Please ask for: Nicola Moore
Email: nicola.moore@arun.gov.uk
Telephone: Ext 37944
Our Ref: AW/130/22/HH
Your Ref:
Date: 15th June 2022

Application for Planning Permission for Works or Extension to a Dwelling

Development: Proposed rear balcony. Removal of pitched roof and replace with new flat roof.
Location: 37 Grosvenor Road Aldwick PO21 3EZ

Roof plan

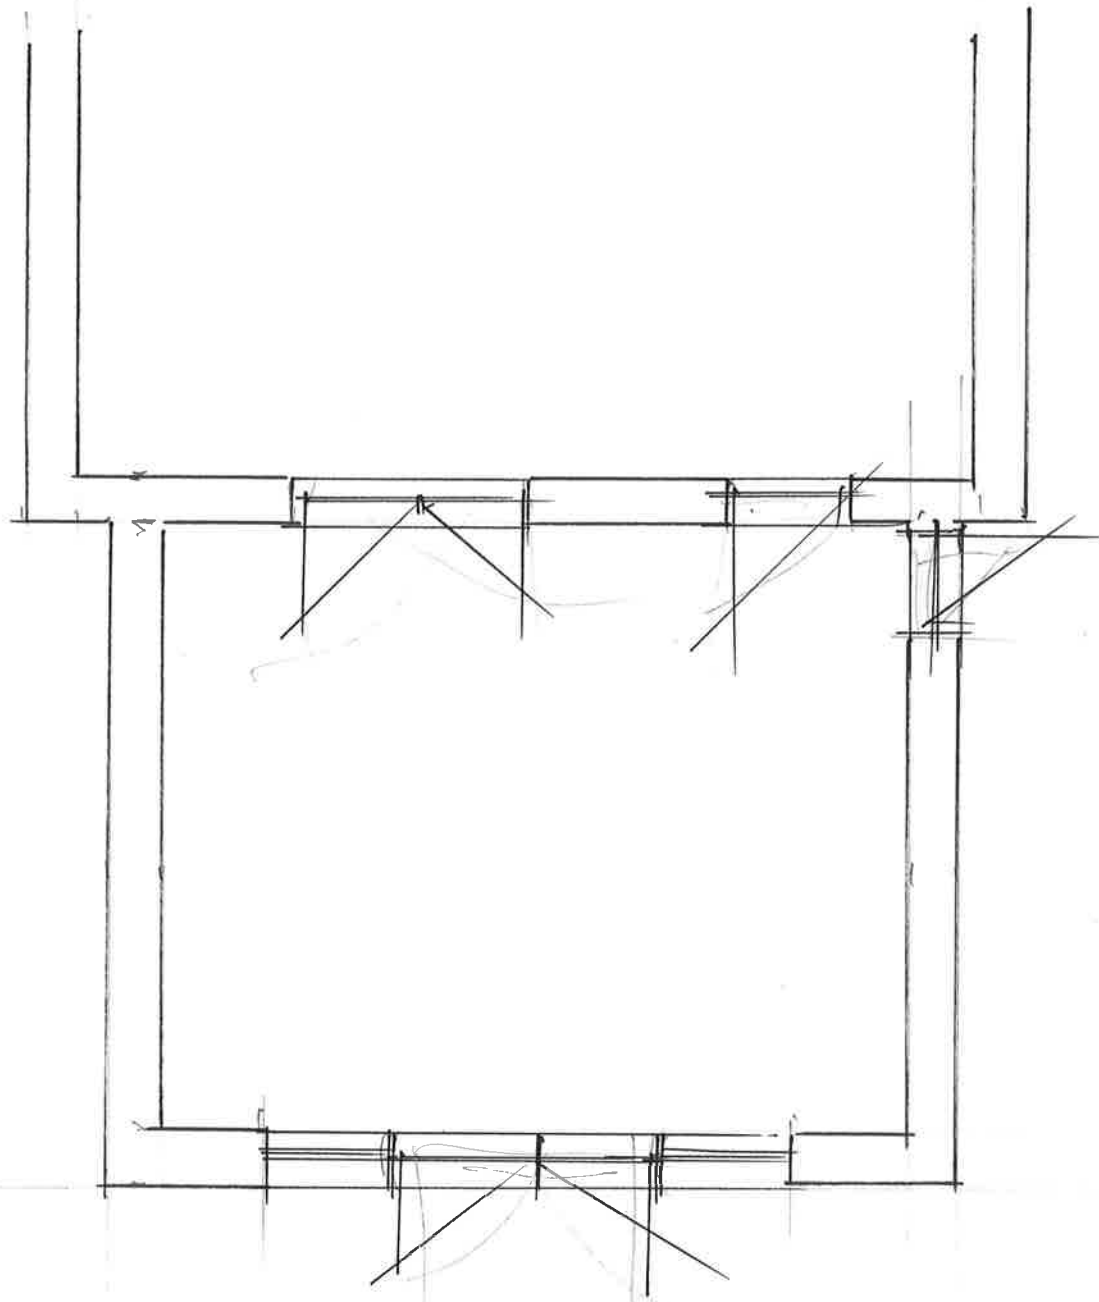
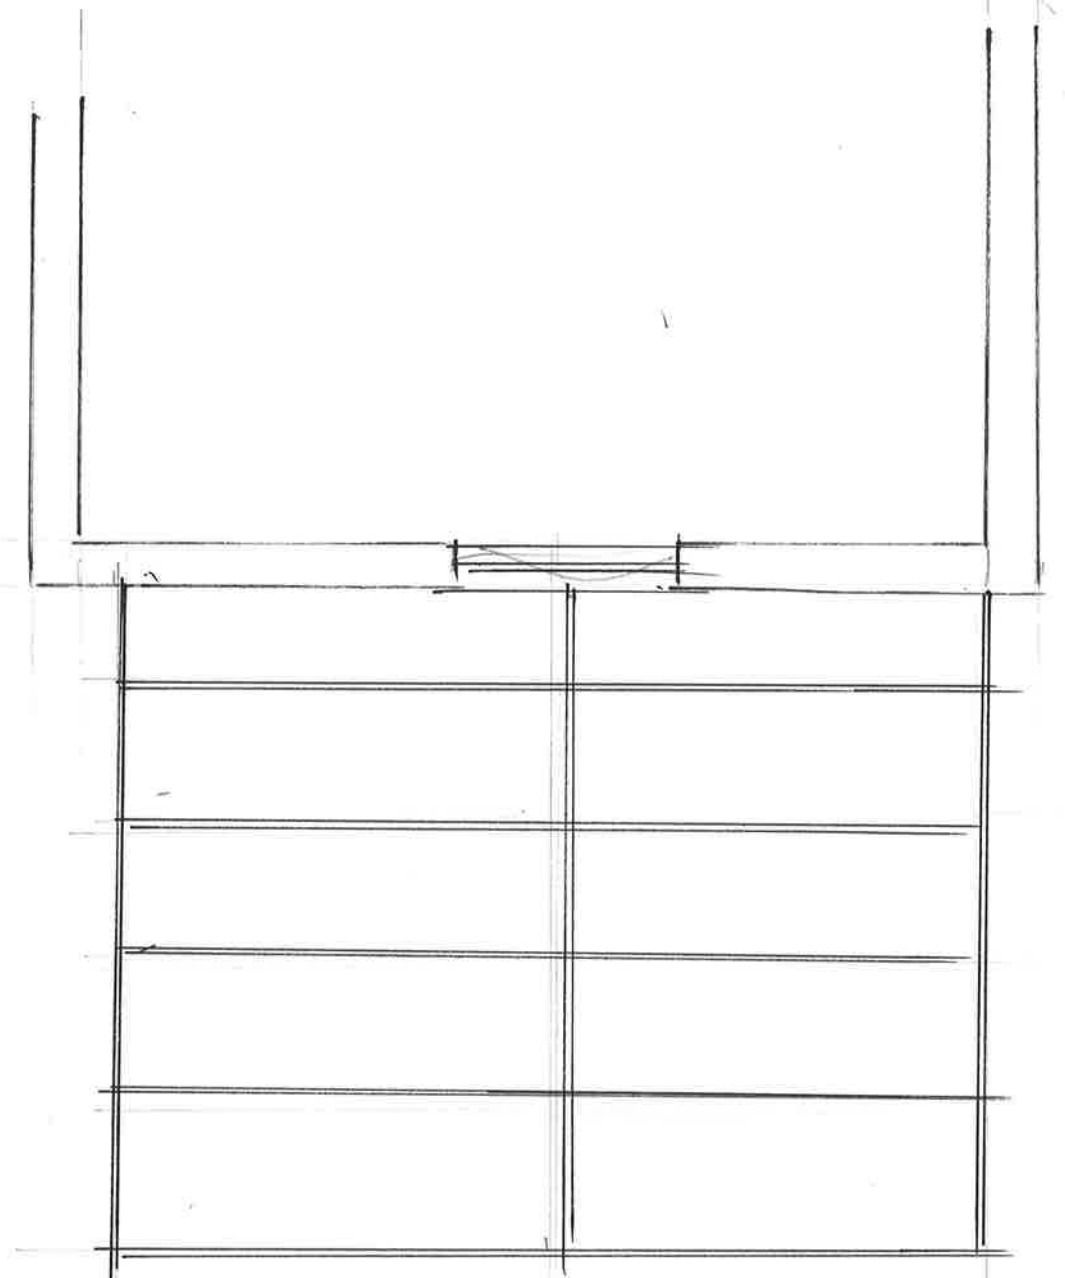
Roof Plan

Please submit electronic plans showing the existing and proposed roof plan. Please refer to the Validation Requirements List for further details.

AS EXISTING

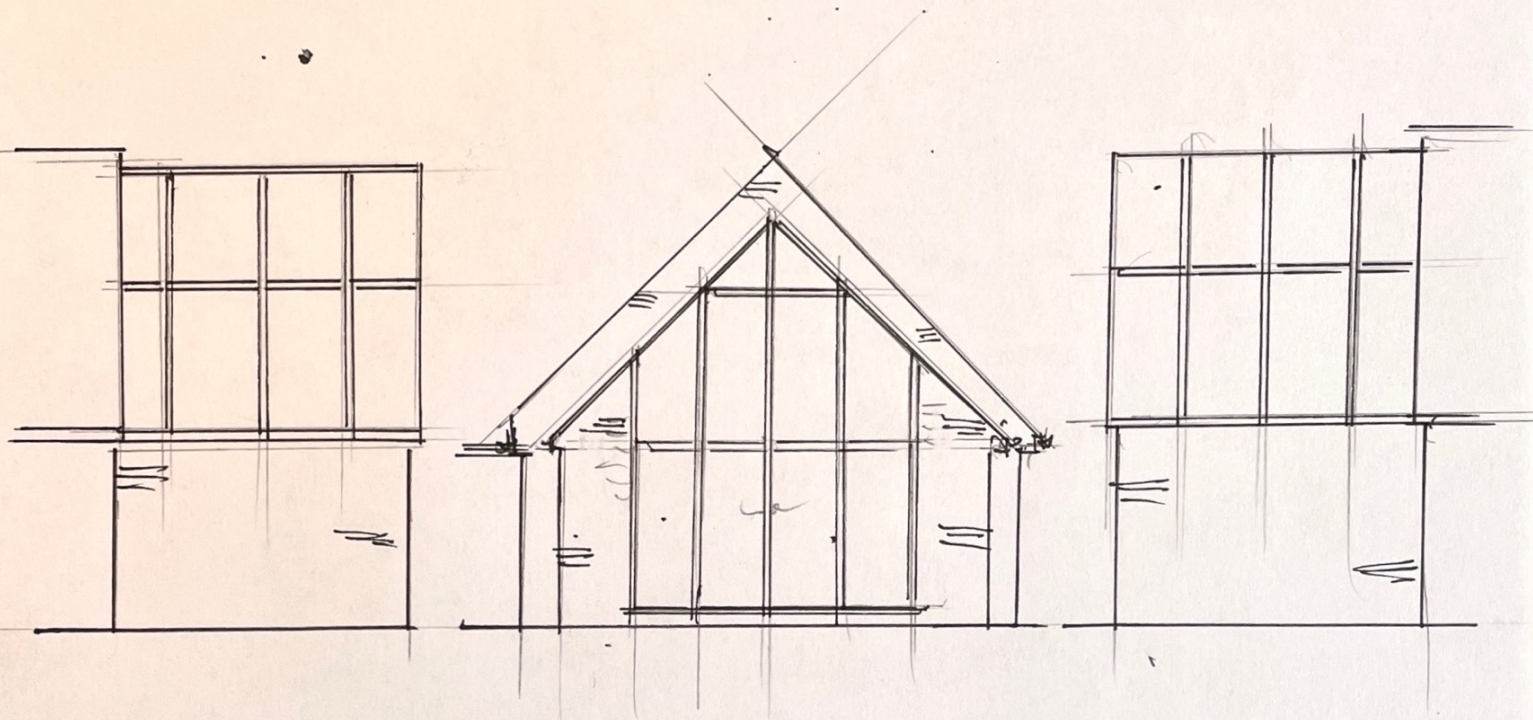
Please submit clearly labelled existing elevations.
